CITY OF ALBUQUERQUE

January 12, 2024

**Re: Champion Xpress Car Wash
5307 4th St NW
Request for Certificate of Occupancy- 30 Day Temp
Transportation Development Final Inspection
Engineer's Stamp Date 5-31-22 (F14D036A)
Certification dated 1-5-24**

CORNER SIDEWALK RAMP EXHIBIT

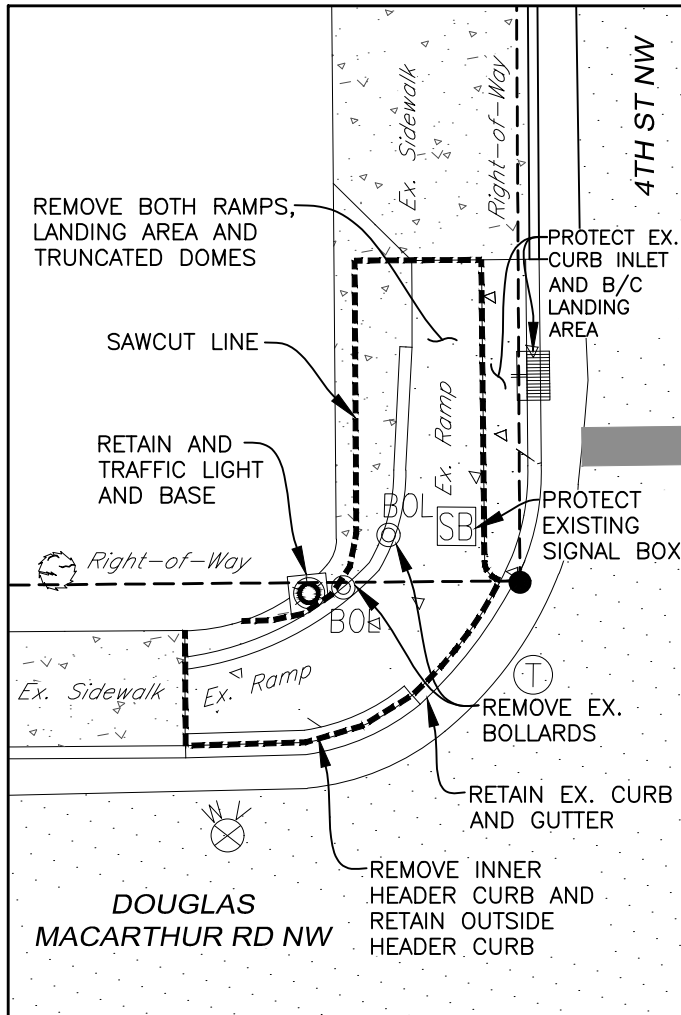
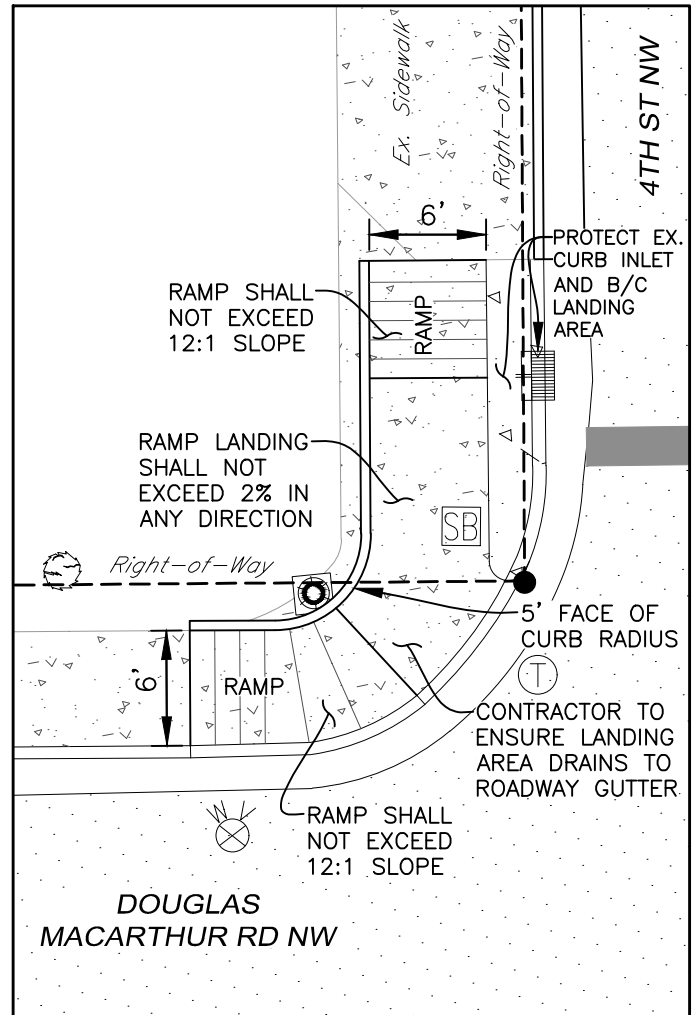
1. There were no pavement markings or signage in the employee parking area.
2. The 6' wide accessible path pavement marking was not installed.
3. Missing pavement markings and signage for the at the tunnel exit.
4. Missing transition sidewalk stone north of the ramp at 4th and Douglas Macarthur.
5. There were a couple of broken sidewalk stones on the Douglas Macarthur portion of the ramp at the 4th and Douglas Macarthur that are to be replaced and the ramp is not 6 feet (44", 60" and 57") wide as shown on the plan and some of the ramp needs to be replaced. I will follow up on this separately.
6. The landscape buffer on Douglas Macarthur was not finished. It needs fine grading and aggregate.
7. The bike rack was not installed.
8. Trim the tree on Douglas Macarthur so the branches don't hang over the sidewalk.
